Demolition of 1 No. existing building & erection of 2 No. 2 bedroom & 2 No. 1 bedroom dwellings.

9 Westloats Lane Bognor Regis

Thank you for your internet representation made on 1st October 2018 which has been recorded as '**an objection**' with the comments as follows:

Project Proposed Site Plan	Sheet 1
Date 2nd May 2018	
Scale 1 : 500

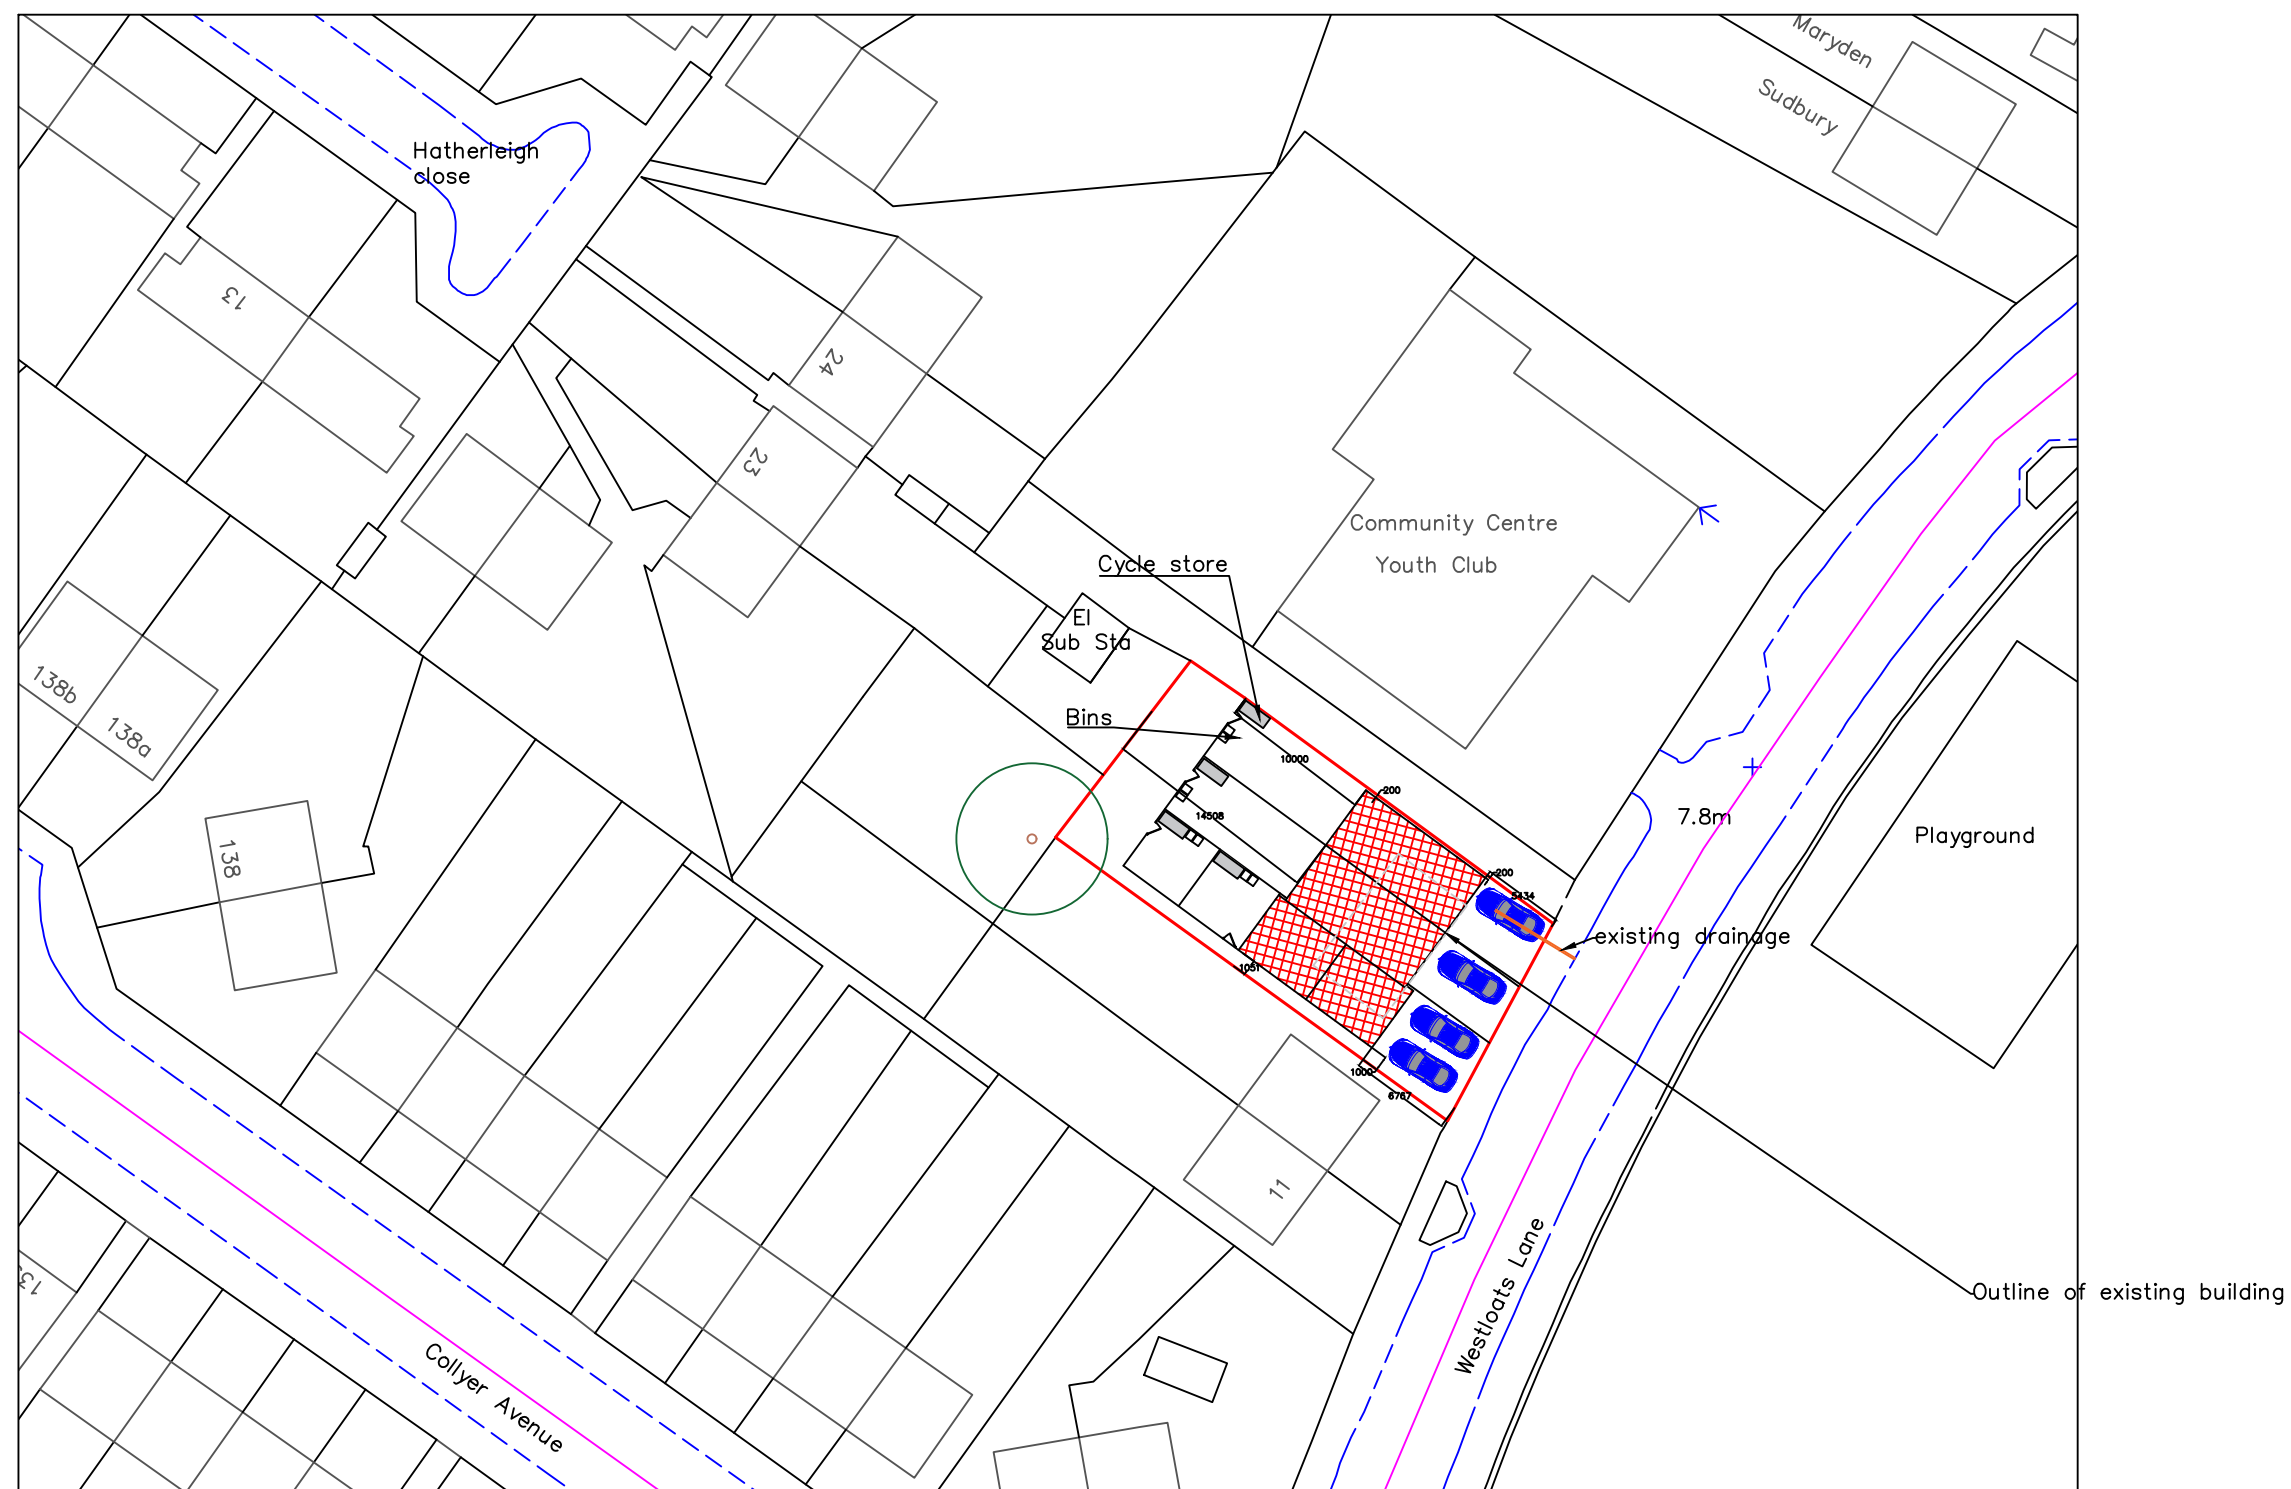
It is noted that the applicant has stated in the Landscaping Strategy that they would look to retain the existing bay laurel tree which is located on the communal space at the rear of the site - whilst this does offer some privacy to both existing properties and to the newbuild houses, it is not guaranteed that this tree will remain once building commences.

It is also noted that the Planning Officer has already raised a query regarding the use of an area of land at the rear of the gardens and back edge of the site. Is it feasible that this area could be utilised for the planting of mature trees to provide the required privacy for both the residents of the existing properties and the new residents?

Rear Elevation

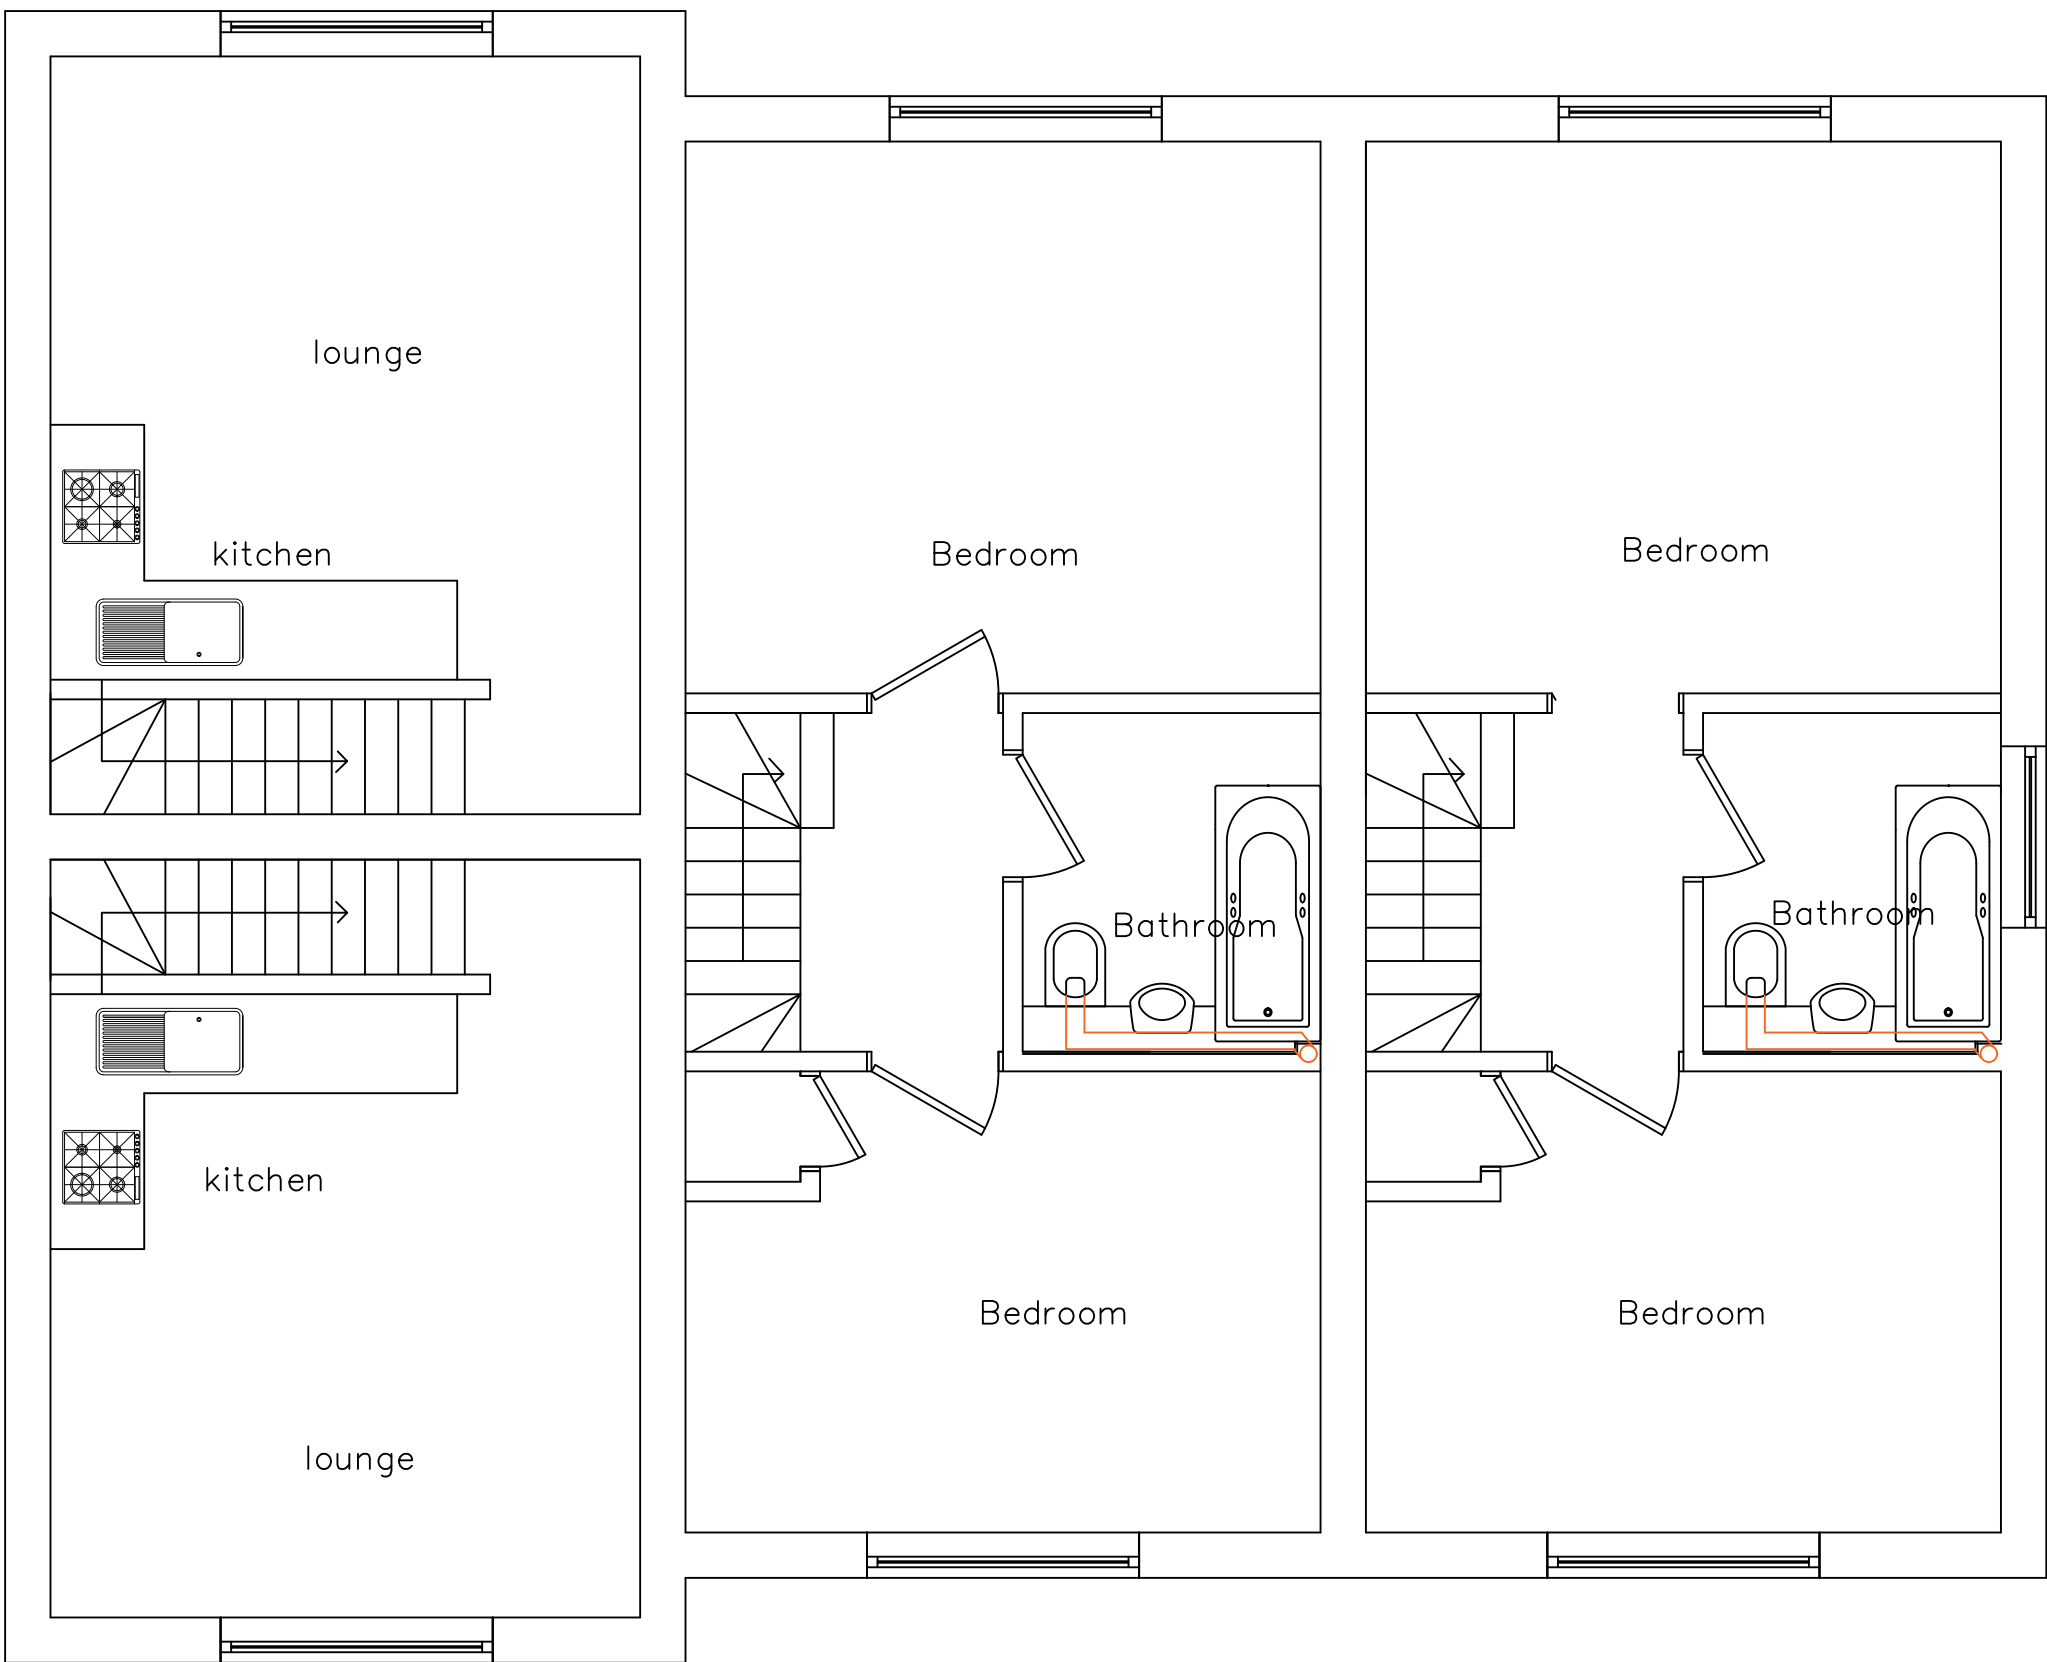
I wish to raise an objection due to the potential loss of privacy on the neighbouring properties located at the rear of the development. The applicant states in the Design Access Statement that the building has been designed so as not to overlook adjoining properties - however this is not the case as the proposed development's footprint is double the size of the existing structure and is situated towards the rear of the site to allow for parking at the front - it is evident from the plans that the upstairs windows will overlook the back of the properties located at the rear. From the plans provided two of these windows will be bedroom windows but my main concern is the lounge window from the upstairs flat which will be the main living area and therefore in constant use.
